Recommendation Report for Planning Permission for Works or Extension to a Dwelling

REF NO: R/259/18/HH

LOCATION: The Rodings
Station Road
Rustington
BN16 3BD

PROPOSAL: 2 No. dormer windows to north elevation, 2 No. rooflights to south elevation, 1 No. rooflight to east elevation & 1 No. rooflight to west elevation. This application may affect the setting of a listed building.

Title
**PROPOSED ROOF PLAN
ELEVATIONS, SECTIONS
EXISTING AND NEW**

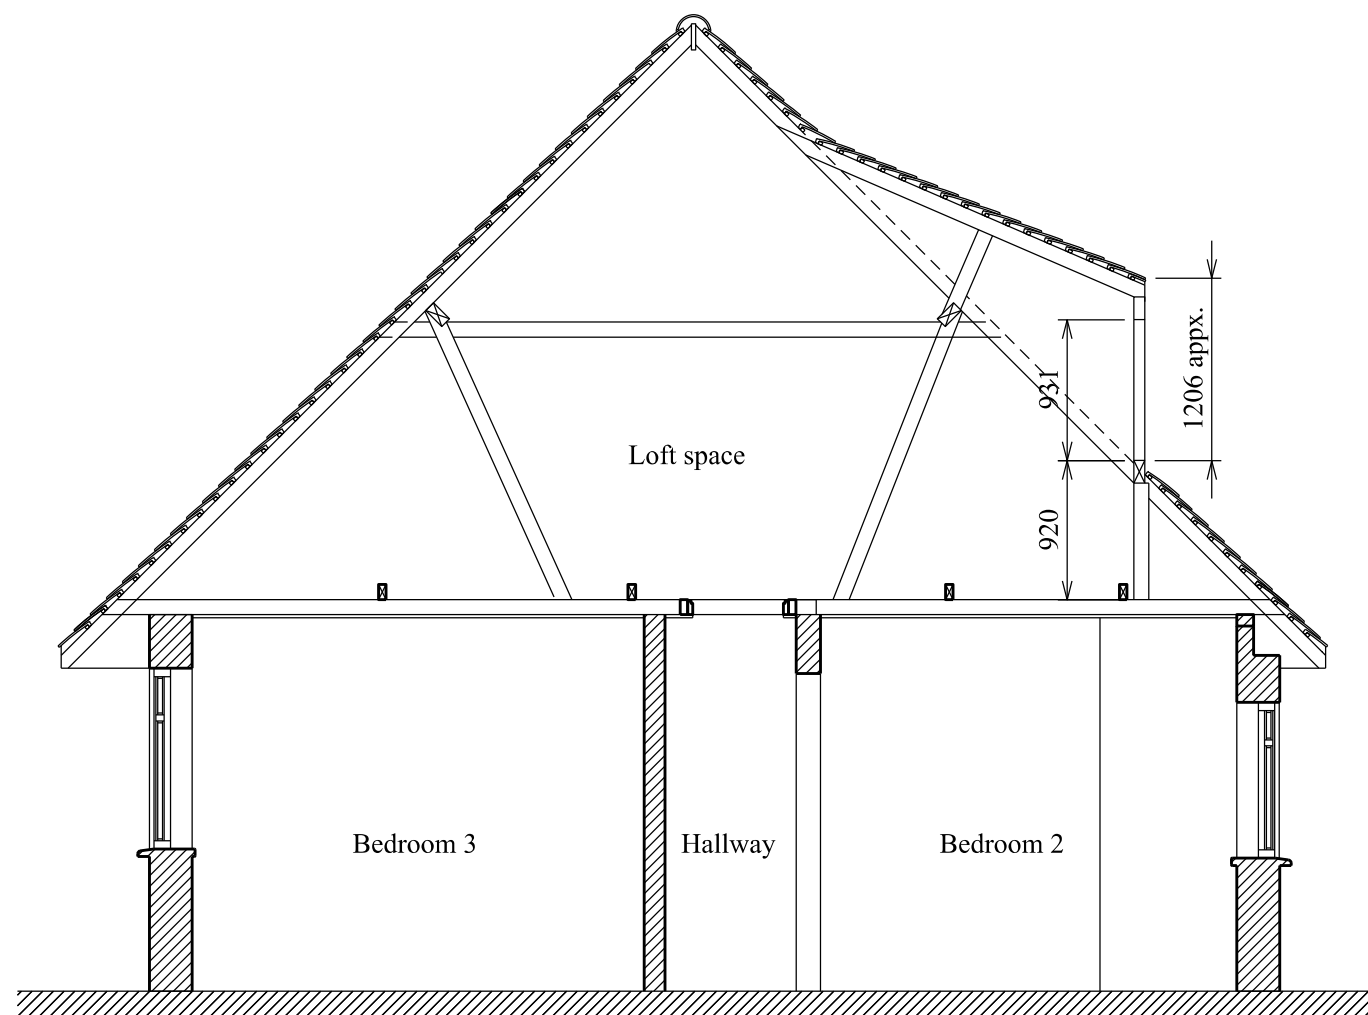
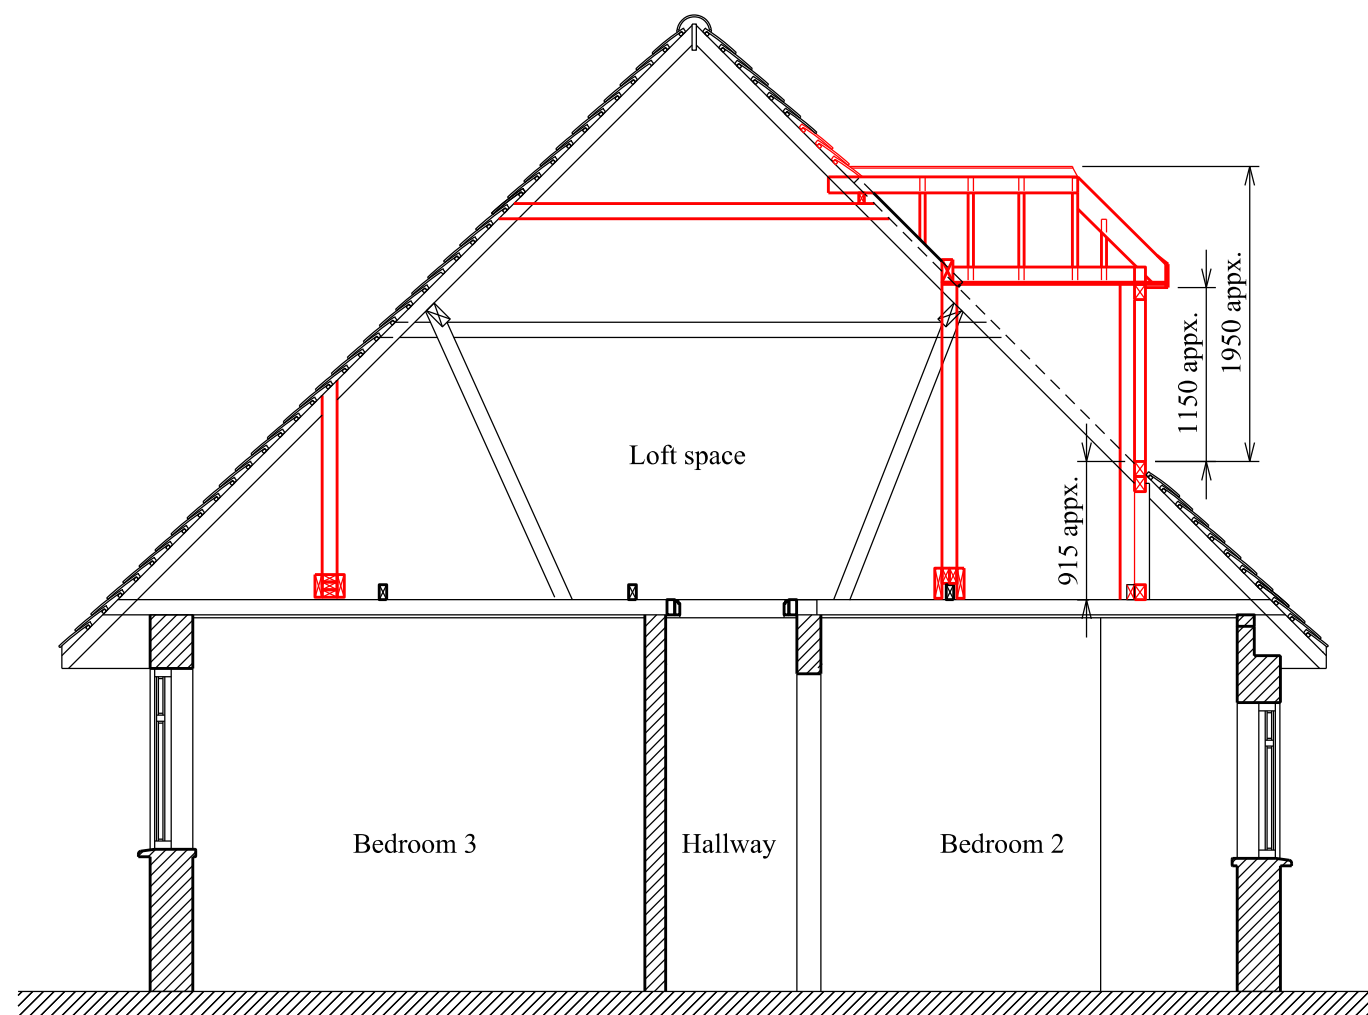
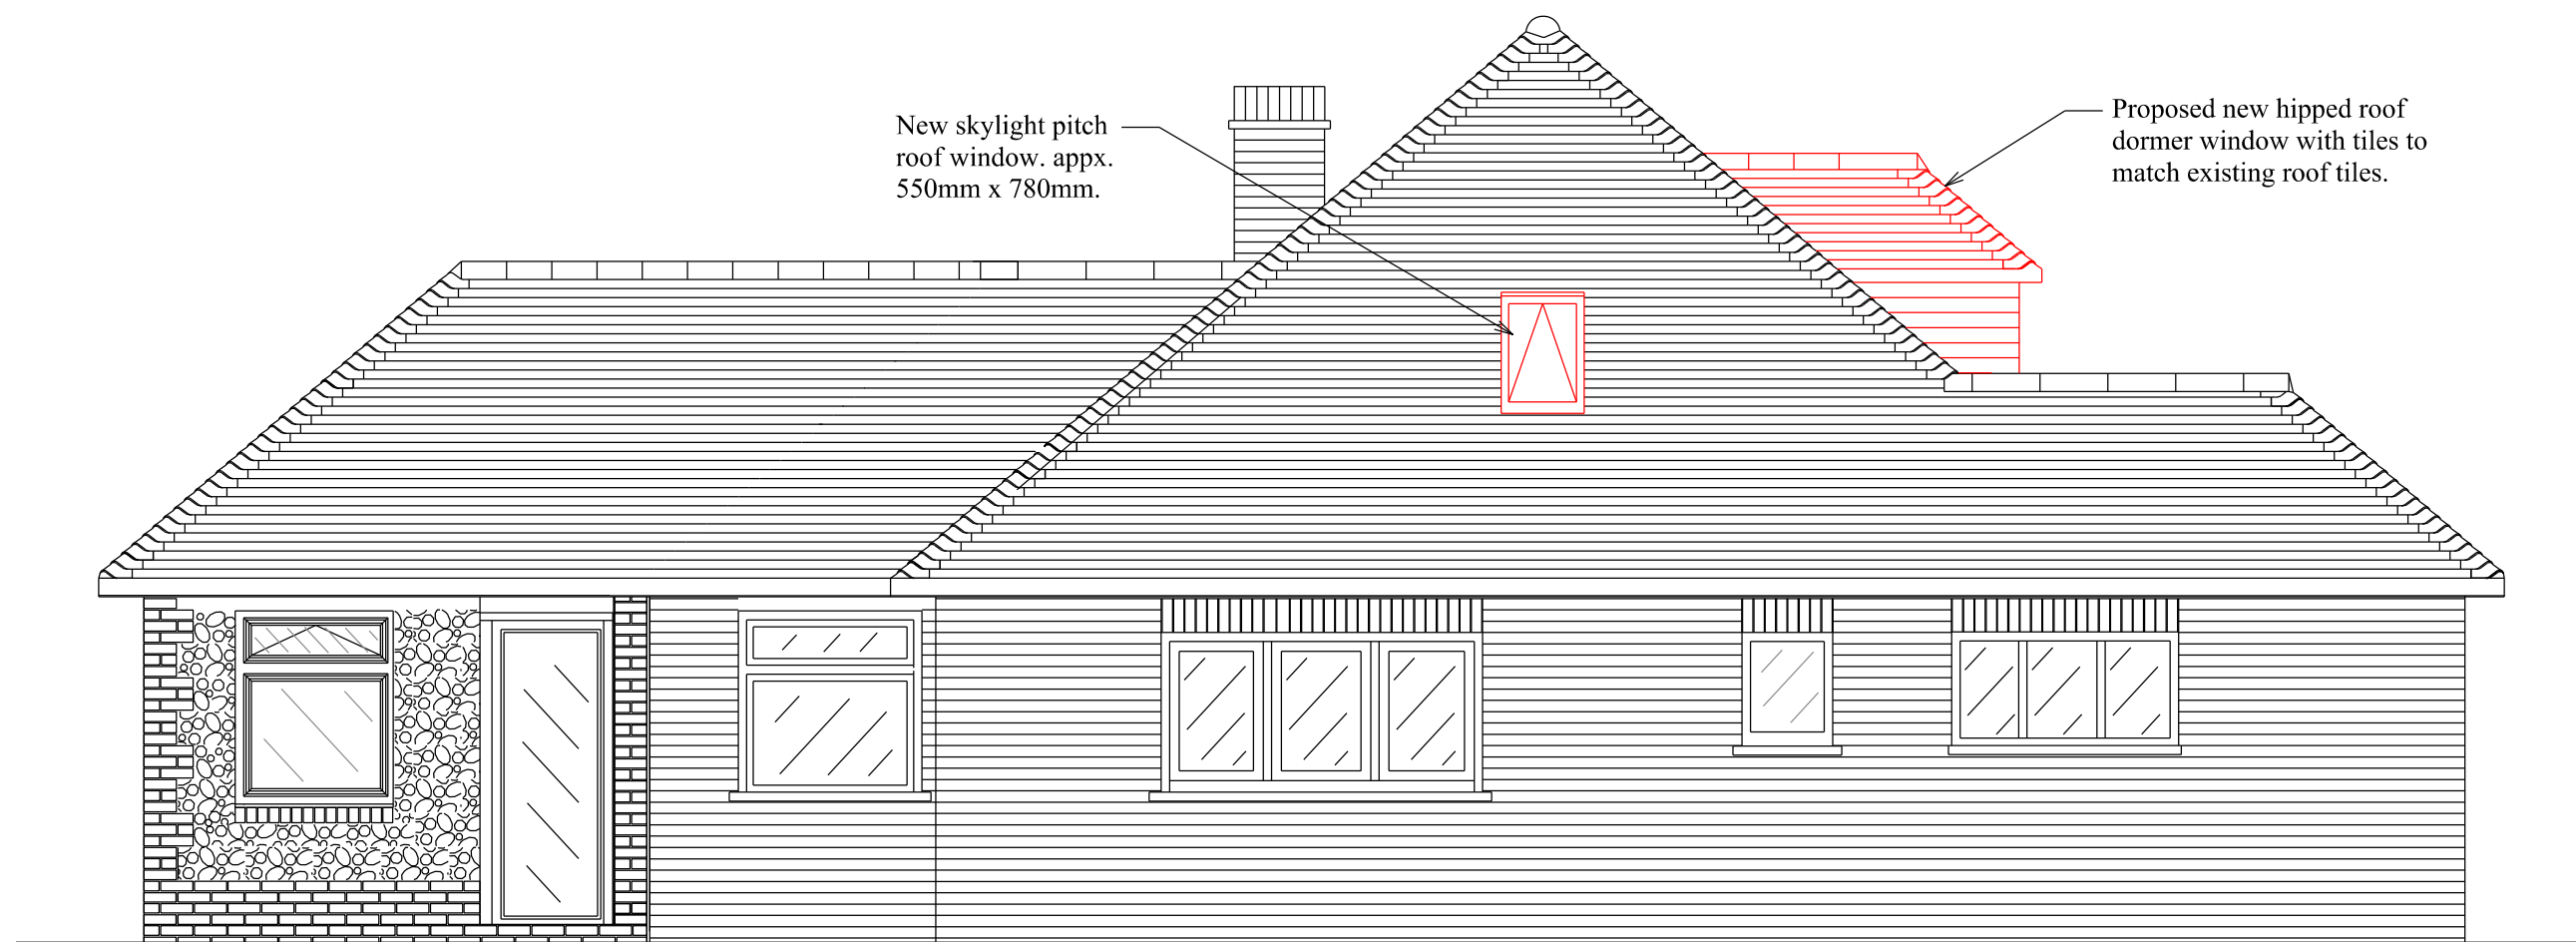
The application site is located close to a listed building. However, scale of the works on the front elevation mean that the proposed dormer windows will not affect the setting of the asset. As a consequence, it is considered that the proposed works will have a neutral impact on the listed building. Materials should reflect those existing on the property.

By virtue of the siting of the proposed development, the front dormers will be clearly visible within the street scene. However, it is considered that as a result of its modest design, it has no significantly detrimental impact upon the established spatial pattern or character of the locality. As a result of the ridge height of the dormers being 0.7m lower than that of the host dwelling, and their materials, it is considered that they appear subservient and well integrated with the host dwelling, and therefore have no unacceptable impact upon its established character.

- 3 The materials and finishes of the external walls and roof of the development hereby permitted shall match in colour and texture those of the existing dwelling.
